From: Nick Fterniatis <Nick.Fterniatis@shfa.nsw.gov.au>
To: "Michael.Buckley@planning.nsw.gov.au" <Michael.Buckley@planning.nsw.gov....>
Date: 19/10/2010 2:58 pm
Subject: Comments on MP 09_0044 for DoP's information

Project Application (MP 09_0044) Park Hyatt Hotel, 7 Hickson Road, the Rocks
Alterations and additions to, and refurbishment of, the existing hotel.

Officers from the Foreshore Authority's Heritage and Urban Design Team have provided the following comments for your information:-

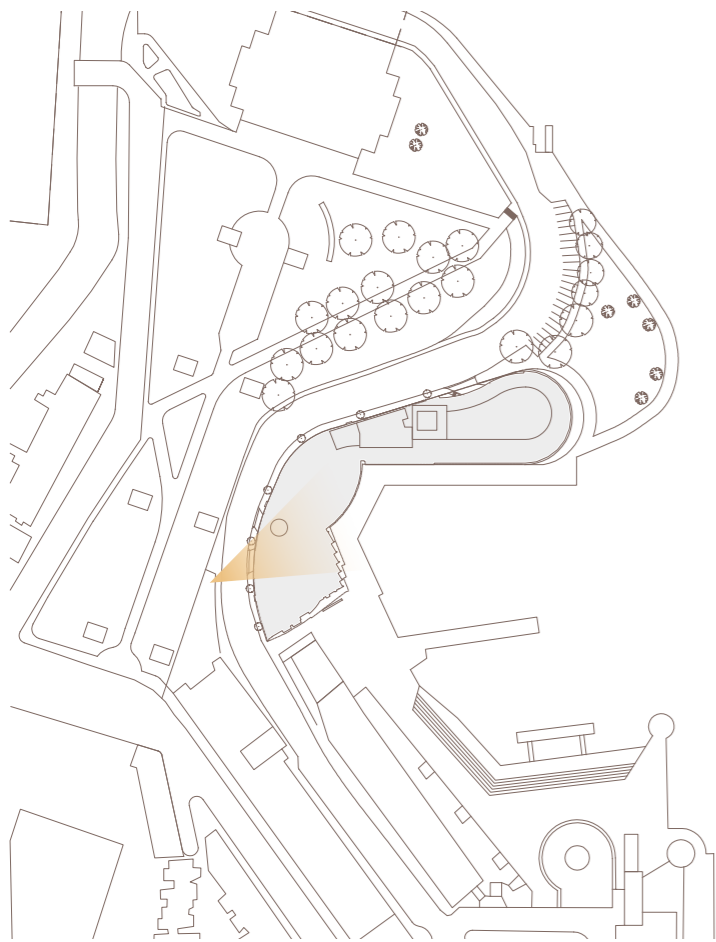
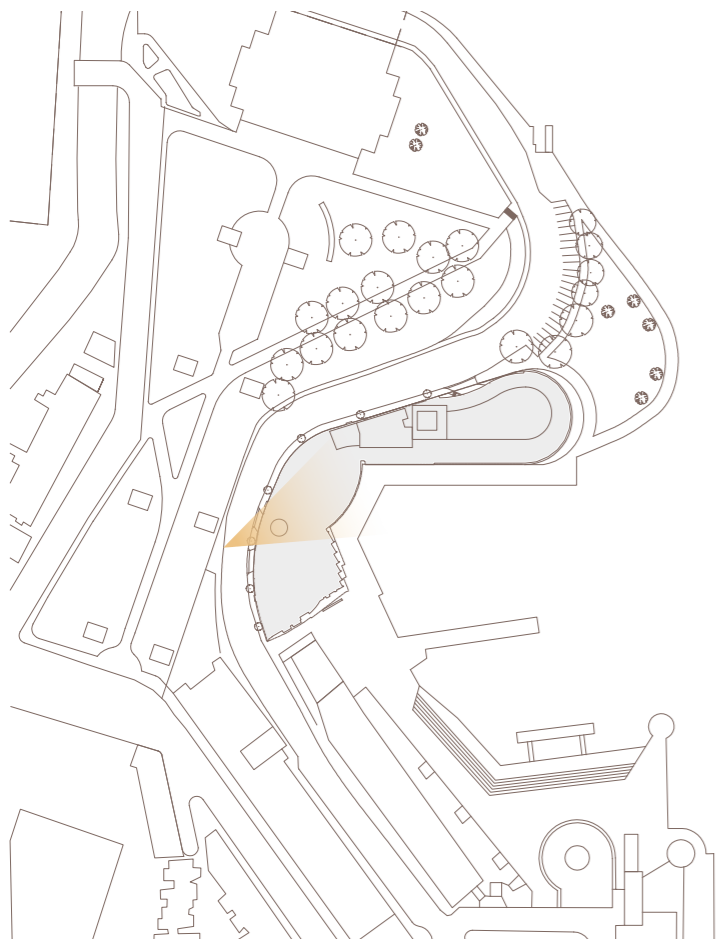
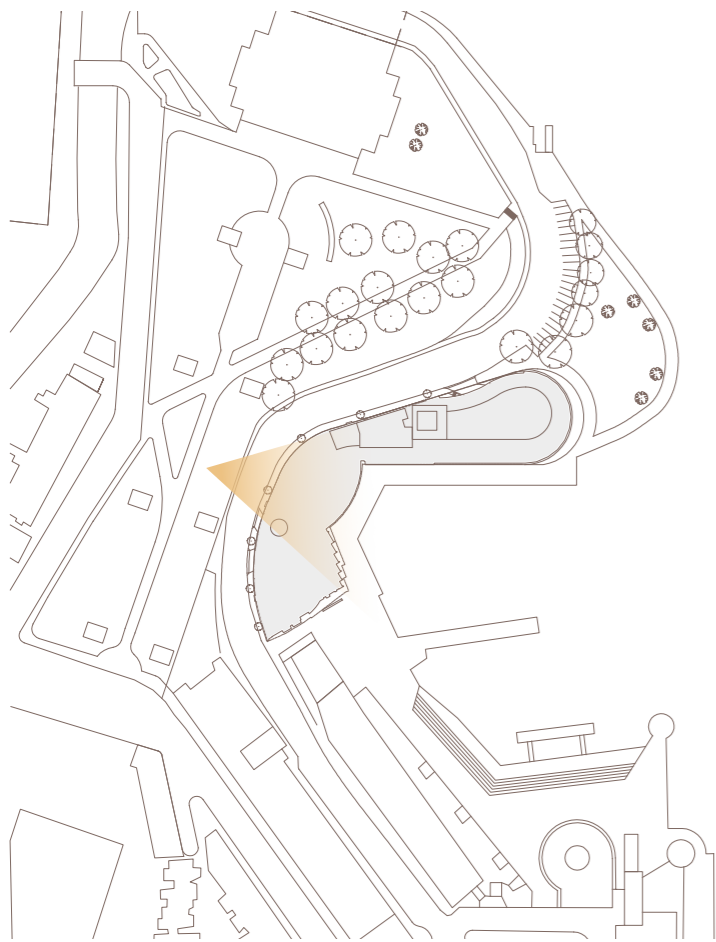
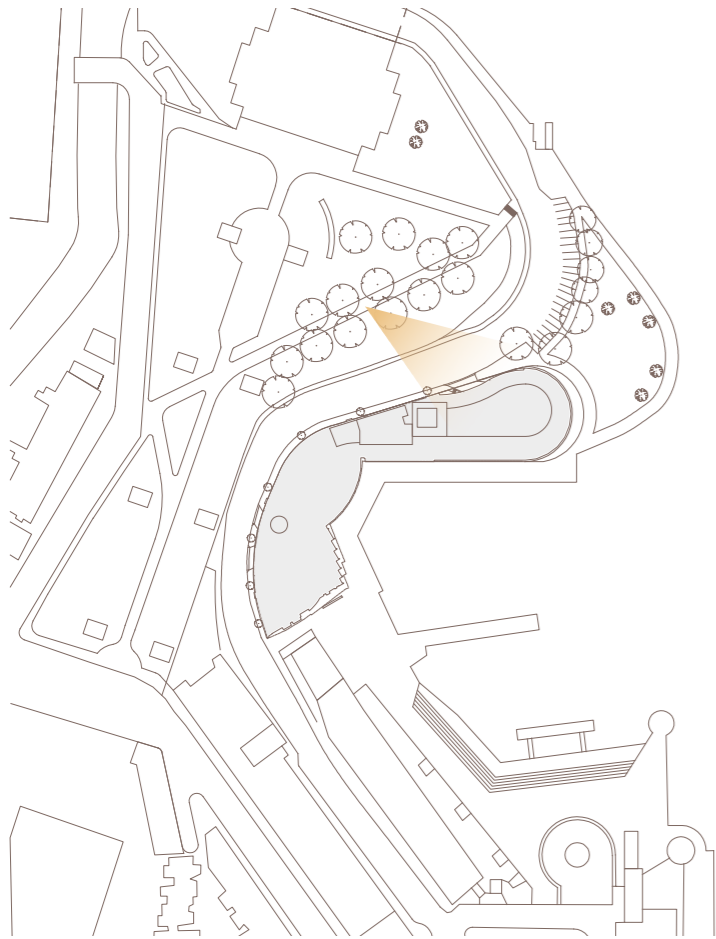
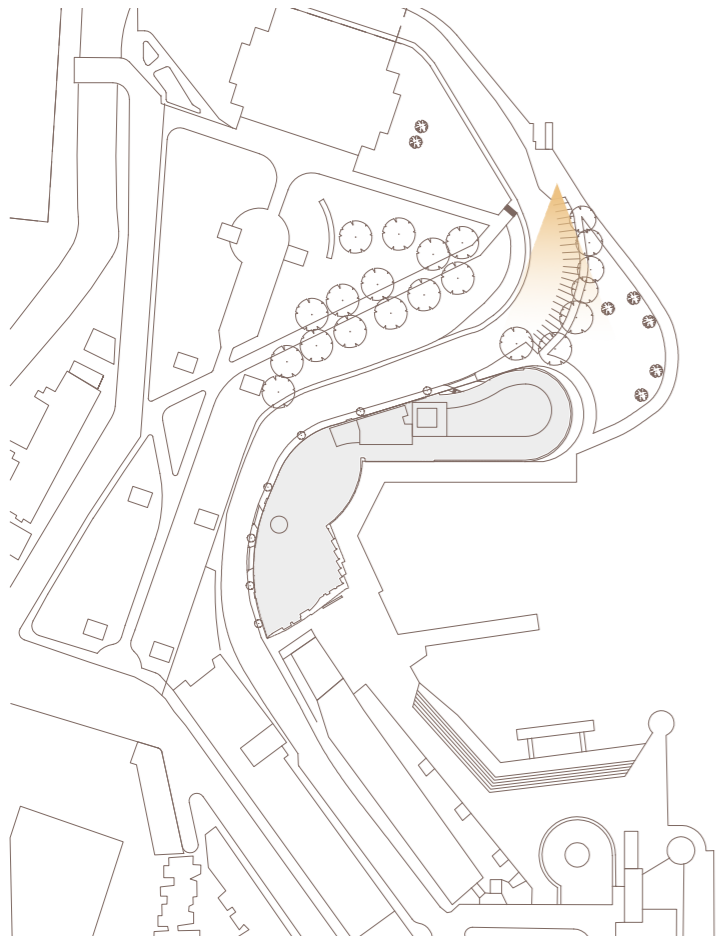
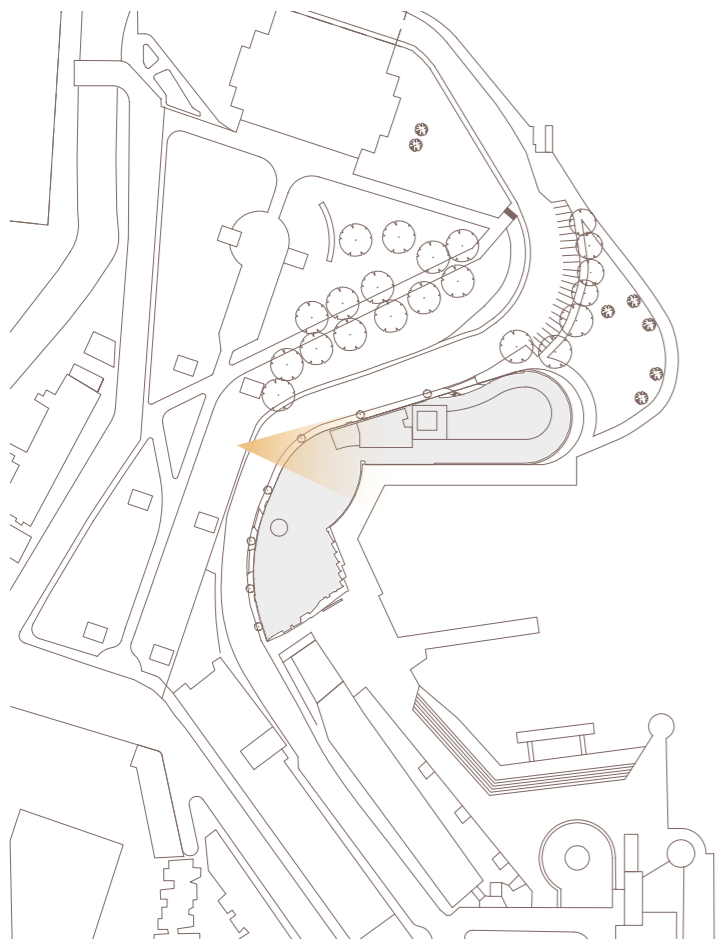
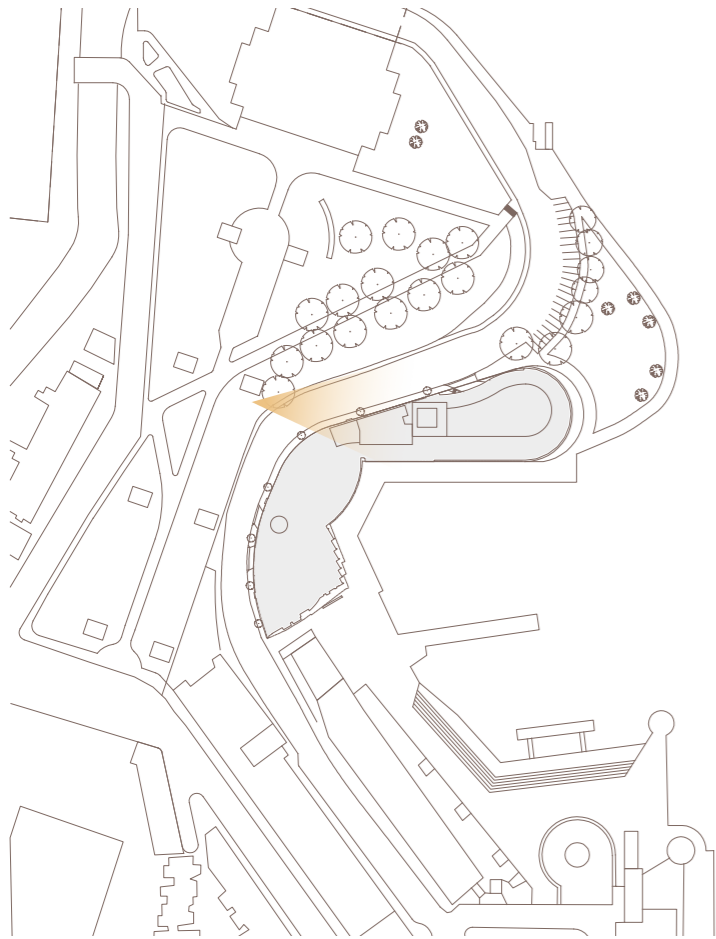
- To better illustrate the proposal, specifically the impact of the rooftop reconfiguration and its impact on water views, we requested that specific panoramic photomontages be constructed from a point halfway between the two bridge piers on Dawes Point, looking in a NE to SE direction, taking in Kirribilli and Circular Quay east. The Environmental assessment report has satisfied this requirement, and the photomontages indicate that the raised and extended pool terrace and its balustrades etc. will make this element will be more prominent from some parts of Dawes Point Park.

We note that the environmental assessment identifies that "there is the potential for some resulting view impact....as a result of the proposed changes to the pool terrace area. The view impact will be the most

prevalent from a small section of Dawes Point Park....The likely impact will be a minor obstruction of view to Sydney Harbour, the Opera House, and its forecourt spaces." (Environmental Assessment Report, July 2010, p. 23). The report also notes that there is an improvement in views from the majority of Dawes Point Park resulting from the lowering of the southern lift shaft.
